Planning Application No: 3/2022/0467

We strongly object to planning application 3/2022/0467 36 Painter Wood - new plans submitted 28th February 2023.

PROPOSED ELEVATIONS

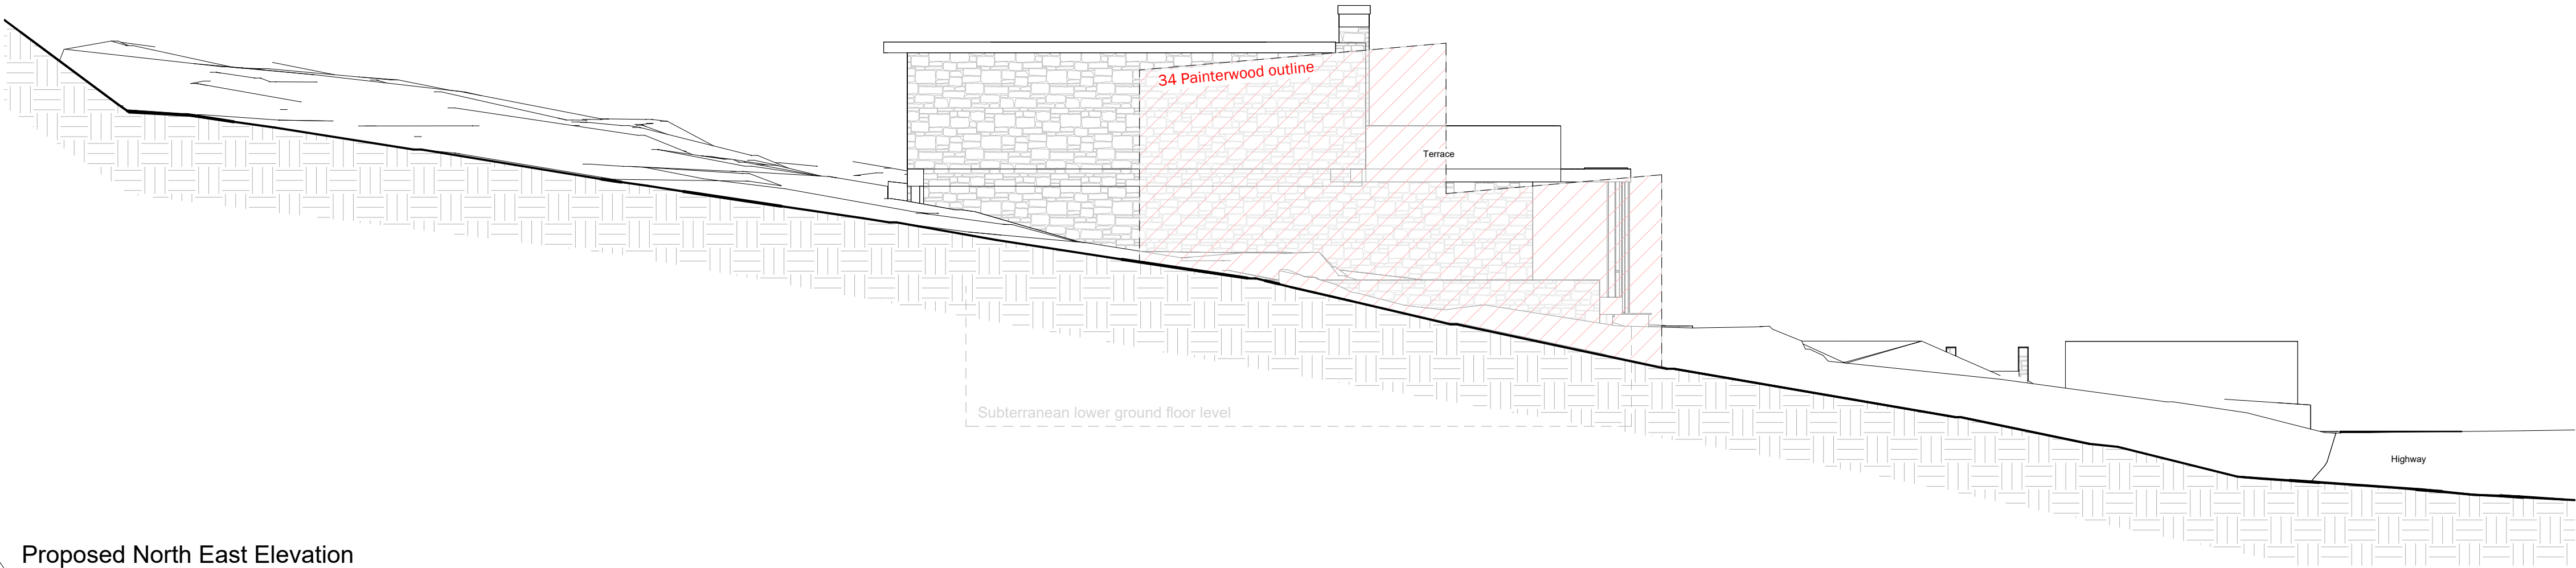
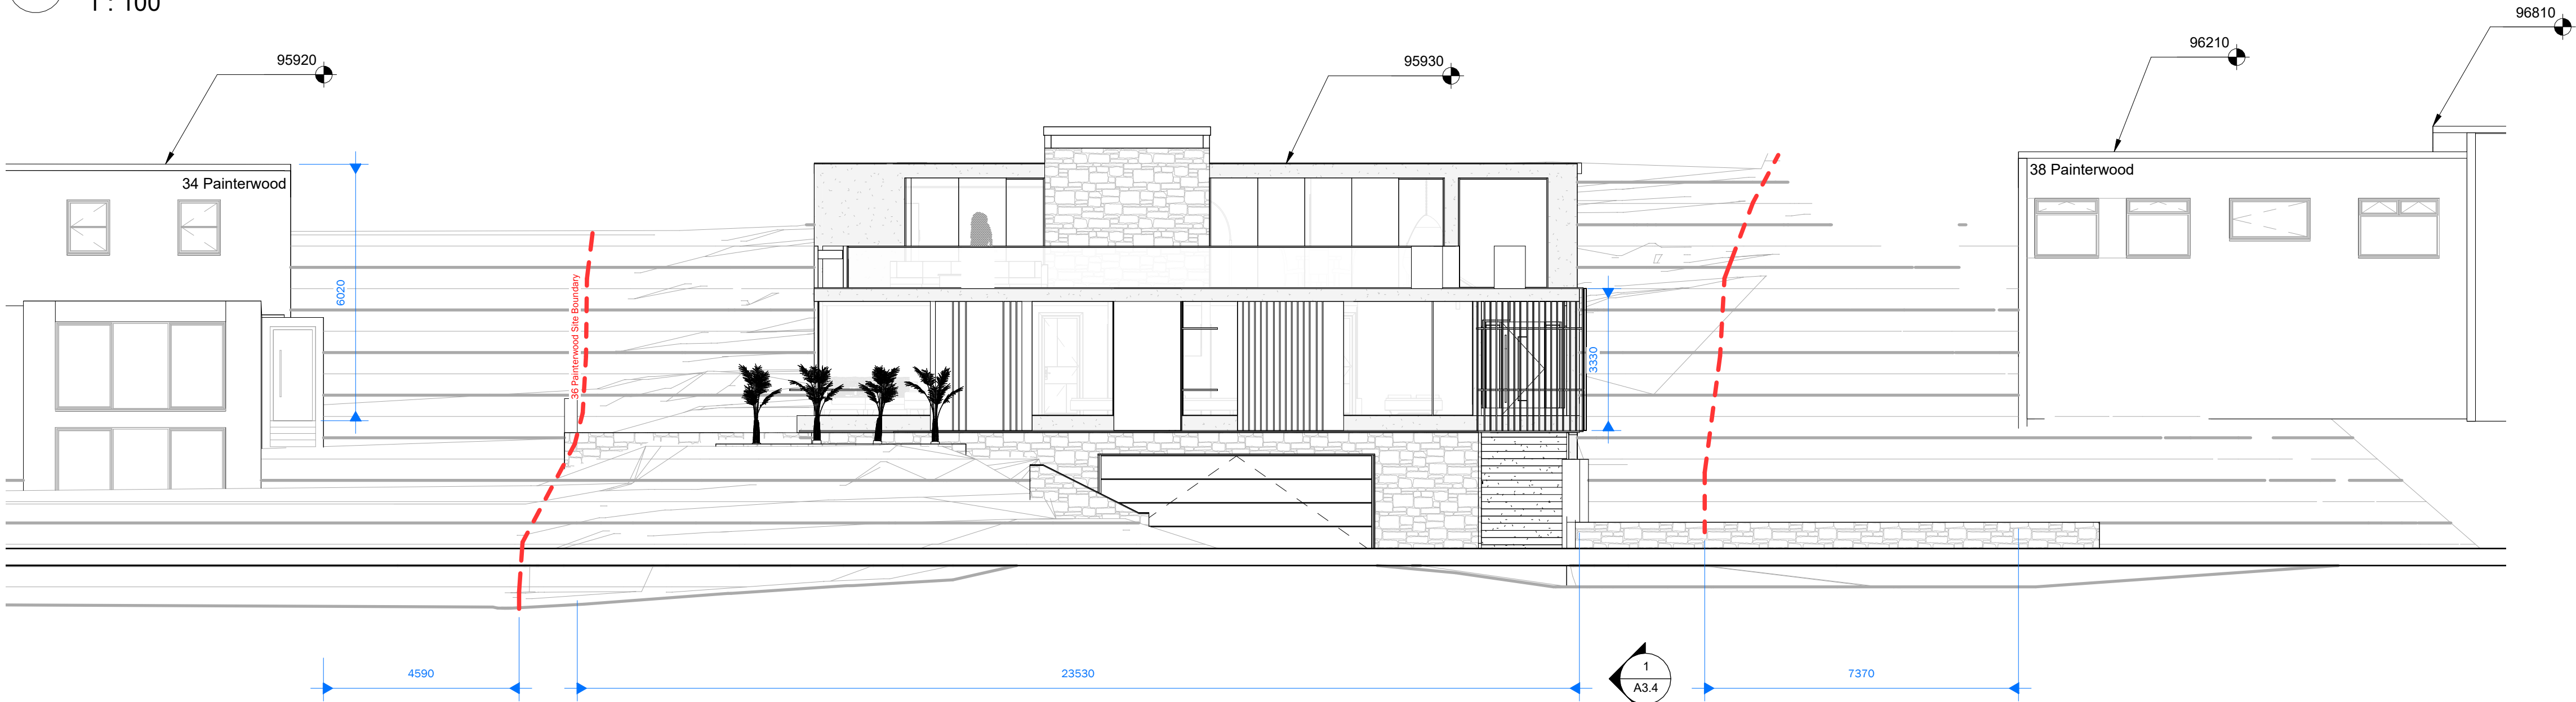
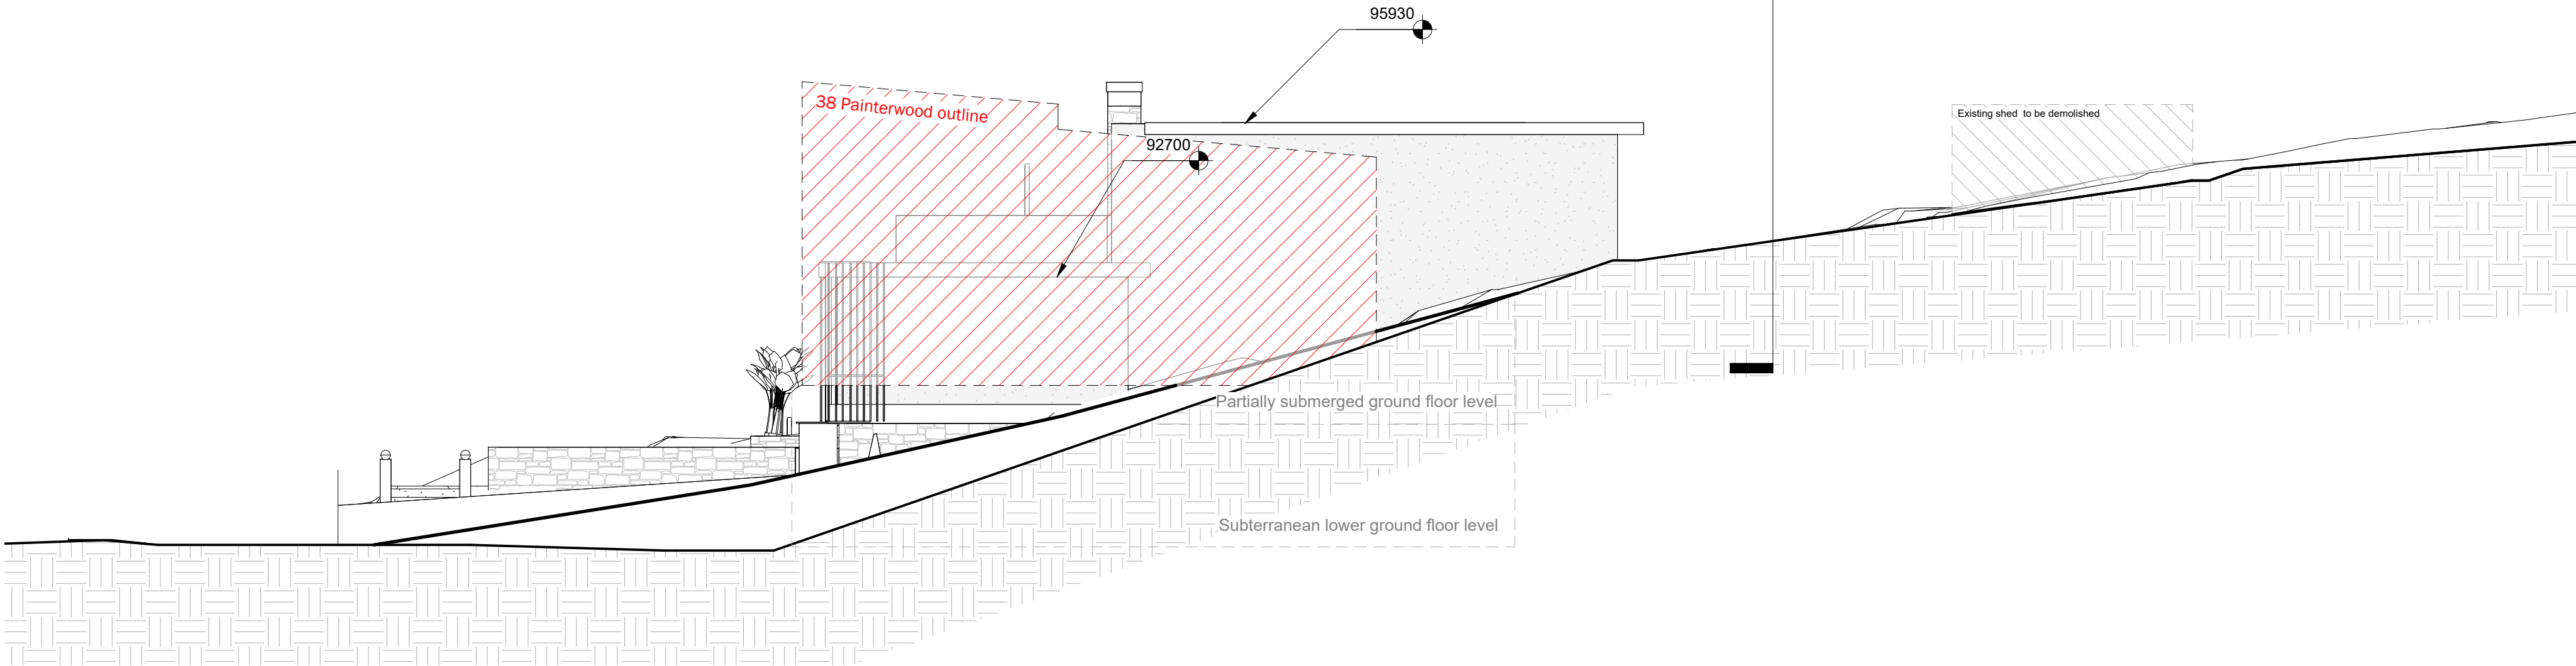
4. The proposed development includes a large stone wall to the north east elevation which will extend up to 12-13m into the garden from the rear of the existing property.

The impact will be **overbearing** and detrimental to both the **openness** and mean a loss of amenity to [REDACTED]

Natural light [REDACTED] will also be severely impacted, especially in Autumn/Winter months when the sun is low on the horizon.
